Addendum No. 1

RE: Contract # C204130

Macon County (R-5734A)

US-23/441 From US-64 To SR-1652 (Wide Horizon Drive)/SR-1152
(Belden Circle) & Bridge # 314 Over Cartoogechaye Creek

PROJECT REFERENCE NO. R-5734A	SHEET NO. UC-04
DESIGNED BY: WMH	
DRAWN BY: RGR/MCM	
CHECKED BY: MCM	
APPROVED BY:	
REVISED:	UTILITIES ENGINEERING SEC. PHONE: (919) 707-6690 FAX: (919) 250-4151
DOCUMENT NOT CONSIDERED FINAL UNLESS ALL SIGNATURES COMPLETED

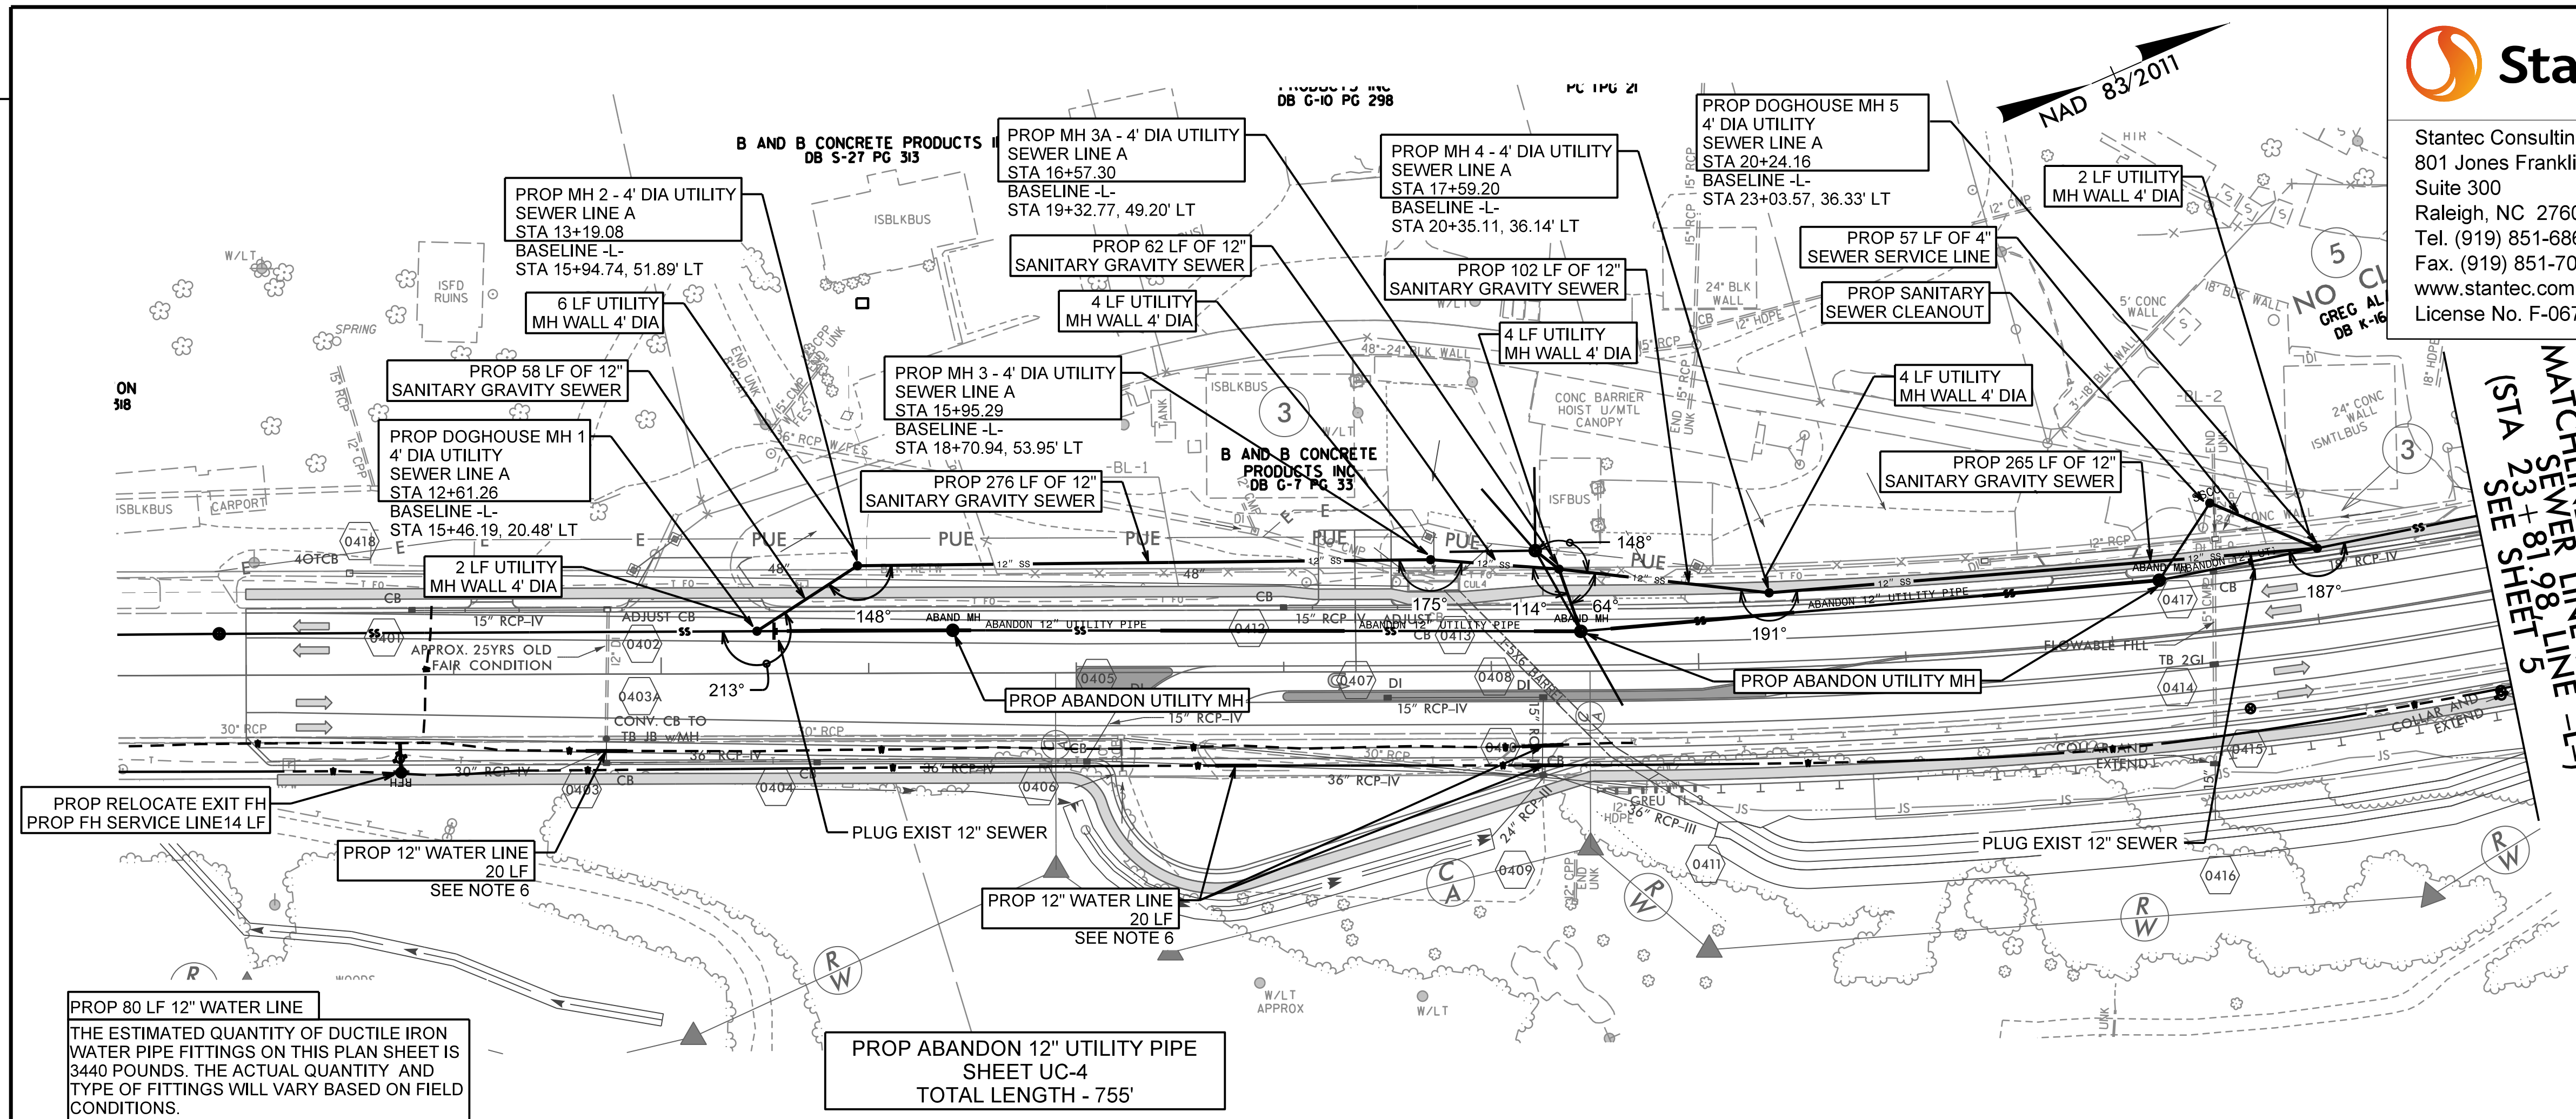
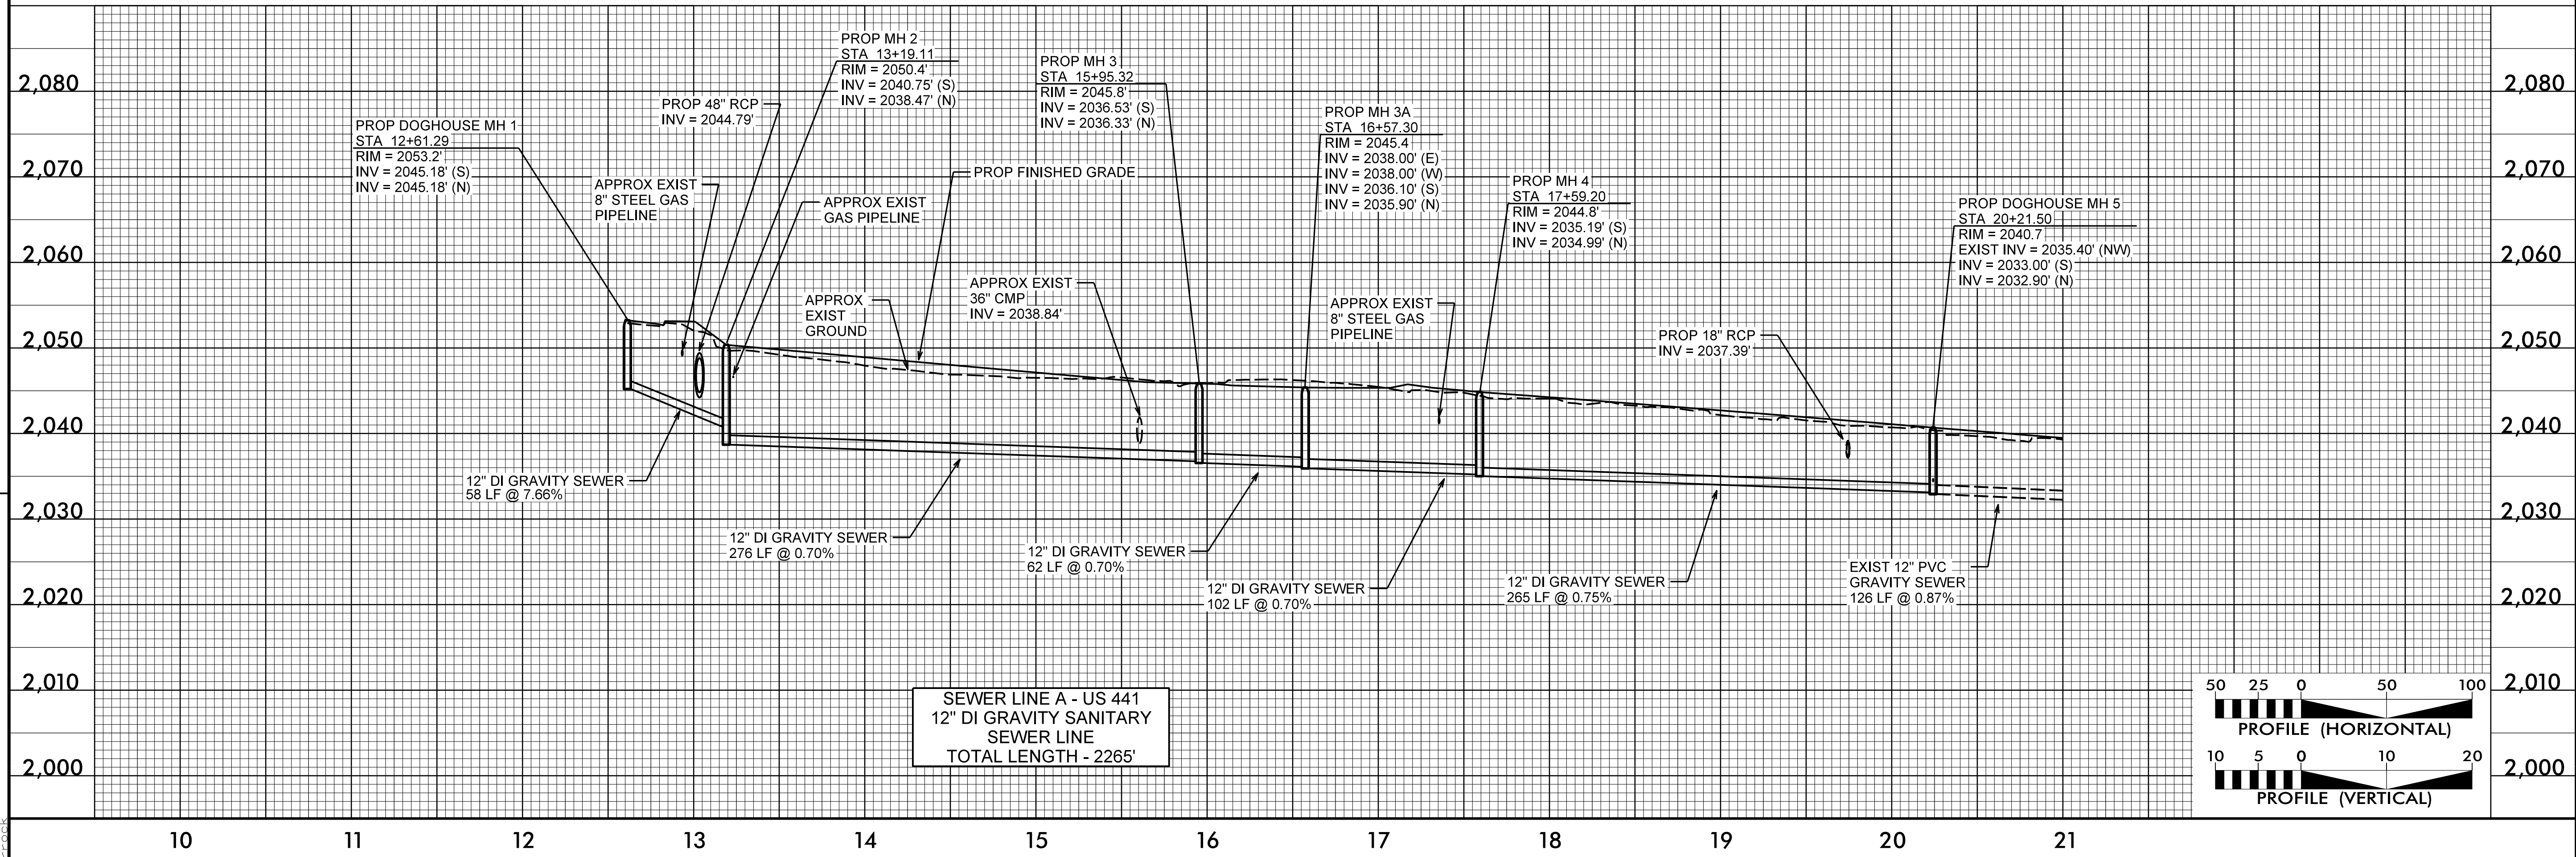
Sheet No.	Revisions
UC-04	New note number 7 added
UC-05	New note number 8 added
UC-08	Waterline crossing the creek was lowered to maintain a minimum vertical separation of 5 feet between bottom of creek bed and top of proposed pipe
UC-09	Proposed hydrant at approximate Sta. 56+00 was removed
UC-10	New note number 3 added
